Rezoning Transportation Analysis
Petition Number: Insert Zoning Petition #2020-194
General Location Identifier: Tax ID 11906424

Revision Log:	Date	Description
	01-21-2021	First Review (KP)
	02-12-2021	Second Review (KP)

The site is located along Toomey Avenue, a City-maintained minor collector, and Tremont Avenue, a City-maintained local street. The petition is in the South Corridor and is inside Route 4. Applicable area plans include the New Bern Transit Station Area Plan.

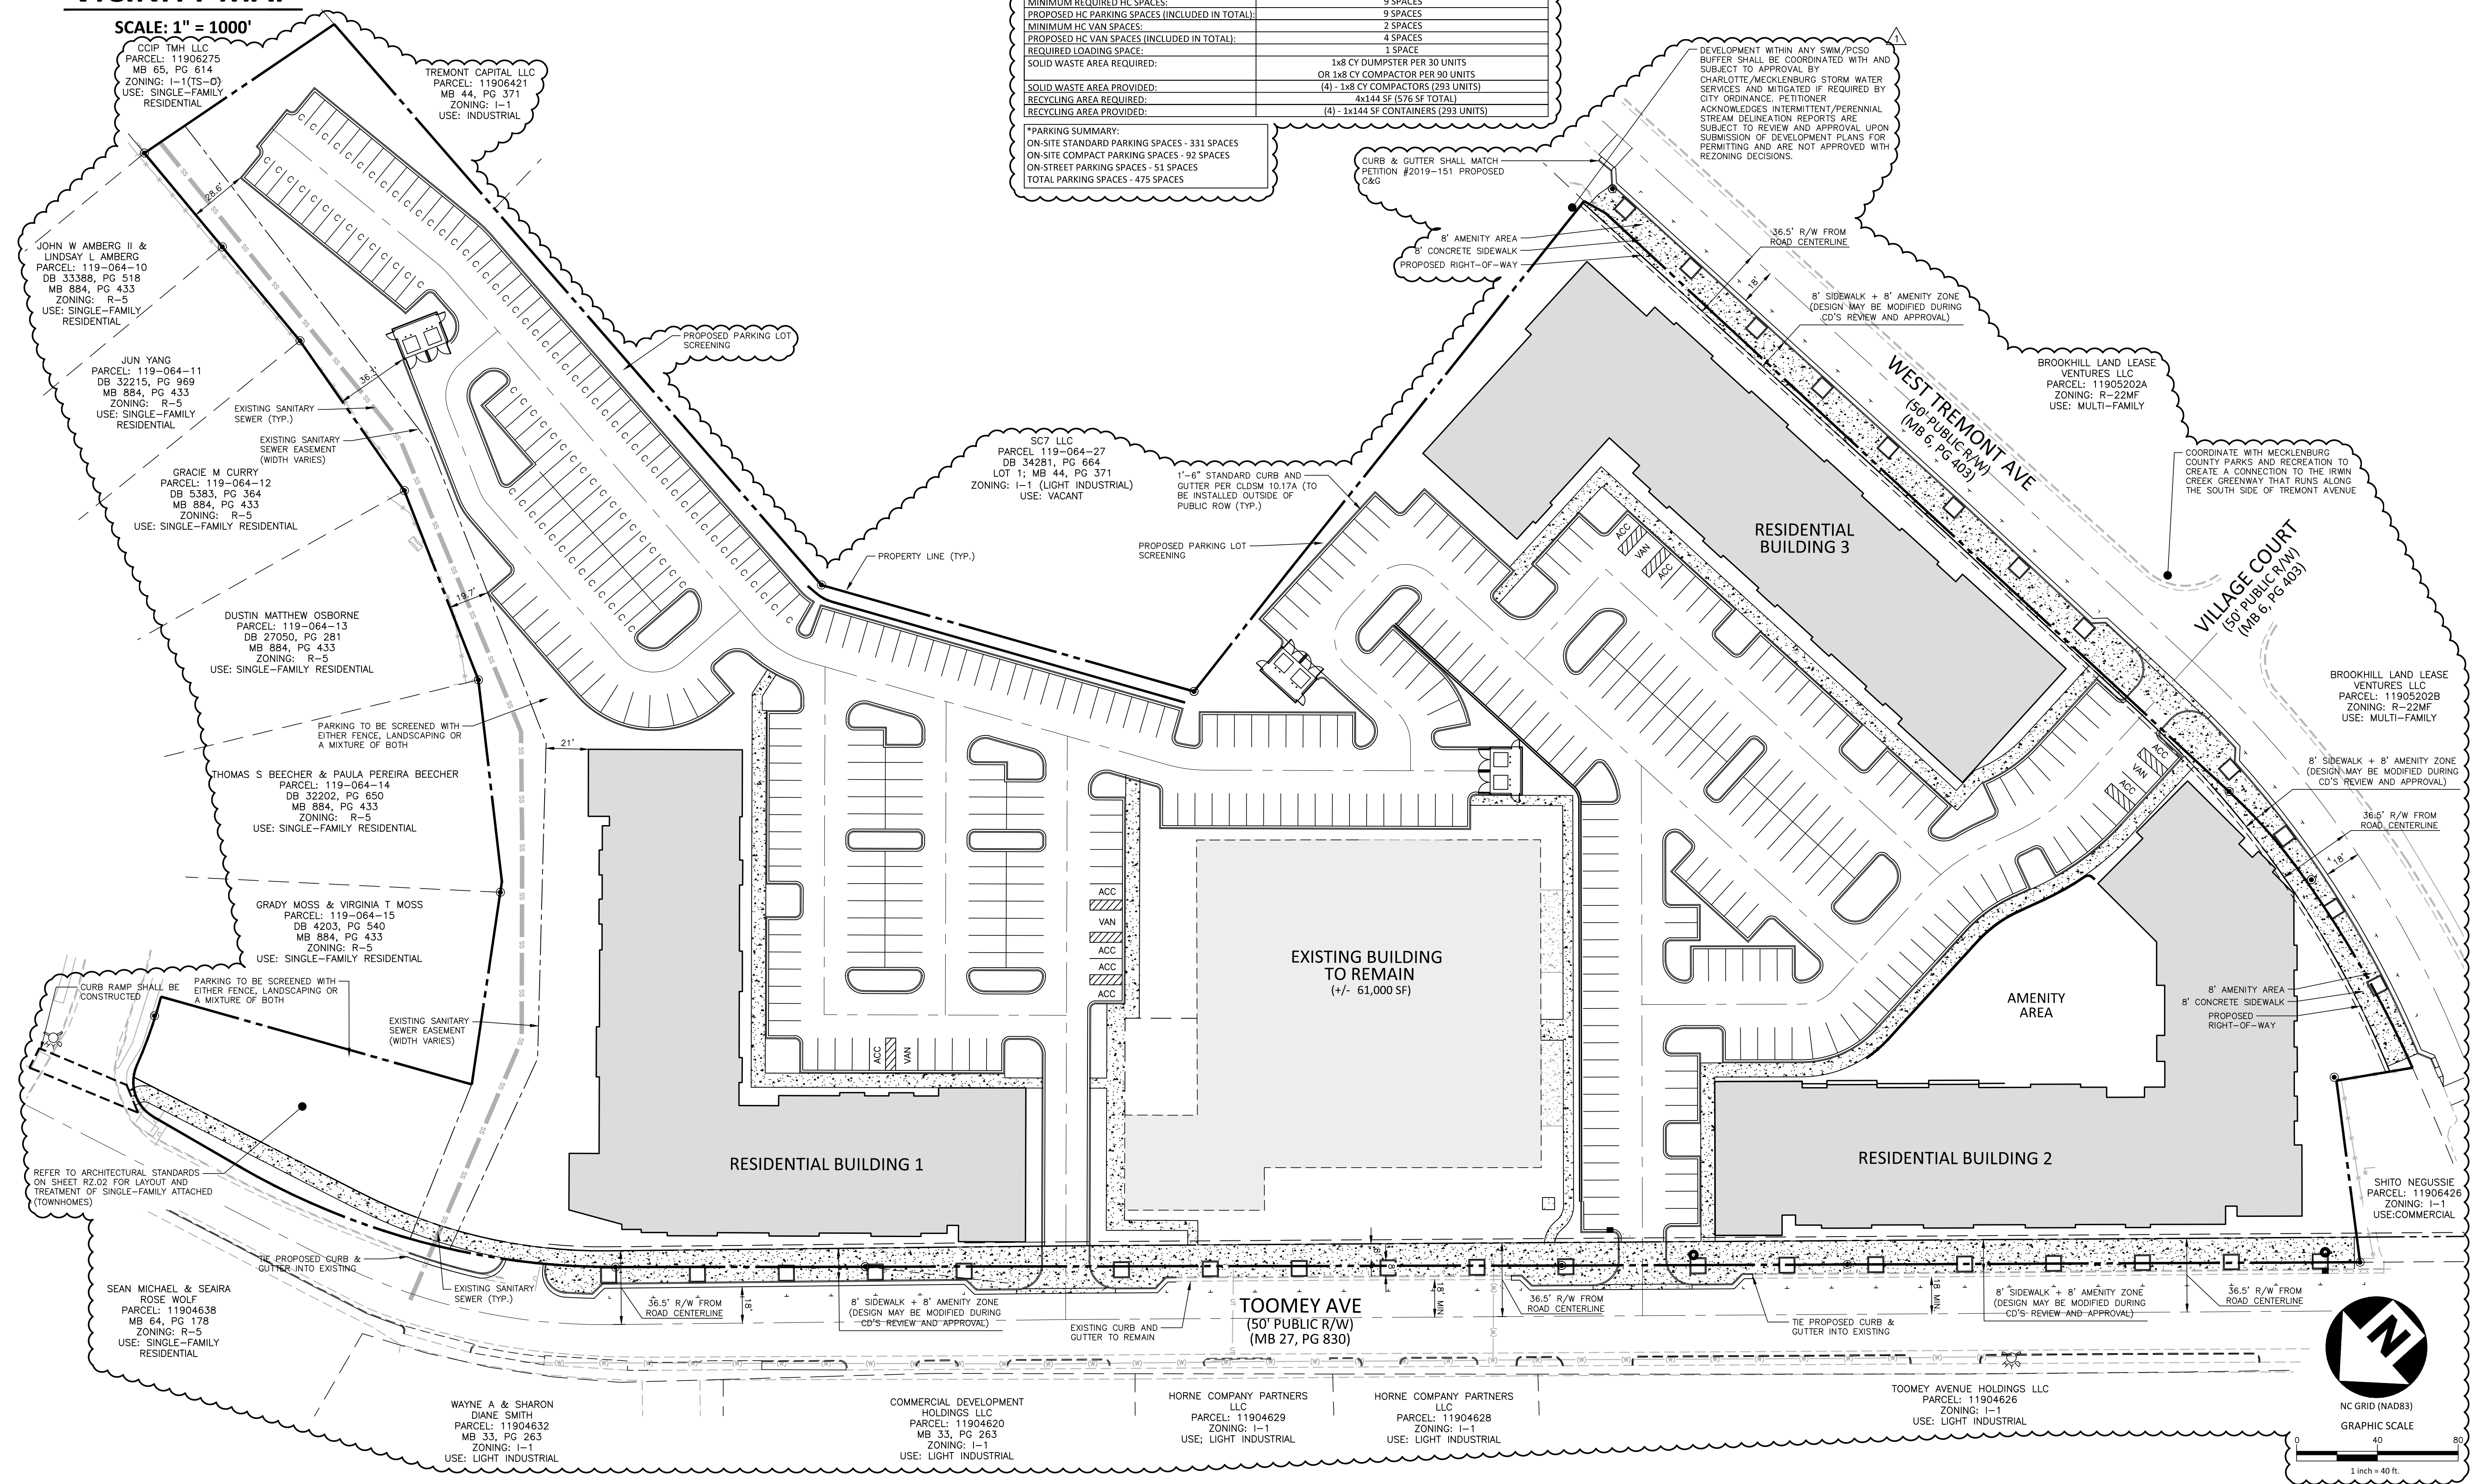
- 4. Revise site plan and conditional note(s) to commit to construct an 8-foot sidewalk, and 8-foot amenity zone, with concrete tree wells, along the site's frontage of Tremont Avenue and Toomey Avenue. Label and dimension both items from the back of curb and gutter and road centerline.

Update to Comment (02-08-2021 Site Plan): Please extend the amenity zone on Toomey Avenue to Wilmore Drive.

7. Revise the site plan and conditional notes by committing to coordinating with the property owner of the parcel at the northeast corner of Tremont Avenue and Toomey Avenue (PID: 11906426), to extend the streetscape (curb and gutter, 8-foot amenity zone, and 8-foot sidewalk) through the property's frontage of Toomey Avenue and Tremont Avenue. Additional driveway cuts and parking accommodations may need to be negotiated with the property owner to accommodate their site's needs.

Update to Comment (02-08-2021 Site Plan): Please update conditional note III.E to state: "The Petitioner shall use good faith efforts to coordinate with the adjacent property owner at the northeast corner of Tremont Avenue and Toomey Avenue (Parcel ID 11906426) to extend the streetscape through the property's frontage of Toomey Avenue and Tremont Avenue. Should the petitioner not be able to obtain this easement, documentation will be submitted to the City during final permitting."

8. Revise the site plan and conditional notes by committing to incorporating on-street parking along the site's frontage Toomey Avenue and Tremont Avenue, in accordance with the CLDSM Detail(s) 50.09C and 50.09D (as necessary).

Update to Comment (02-08-2021 Site Plan): Please extend the on-street parking on Toomey Avenue to Wilmore Drive.
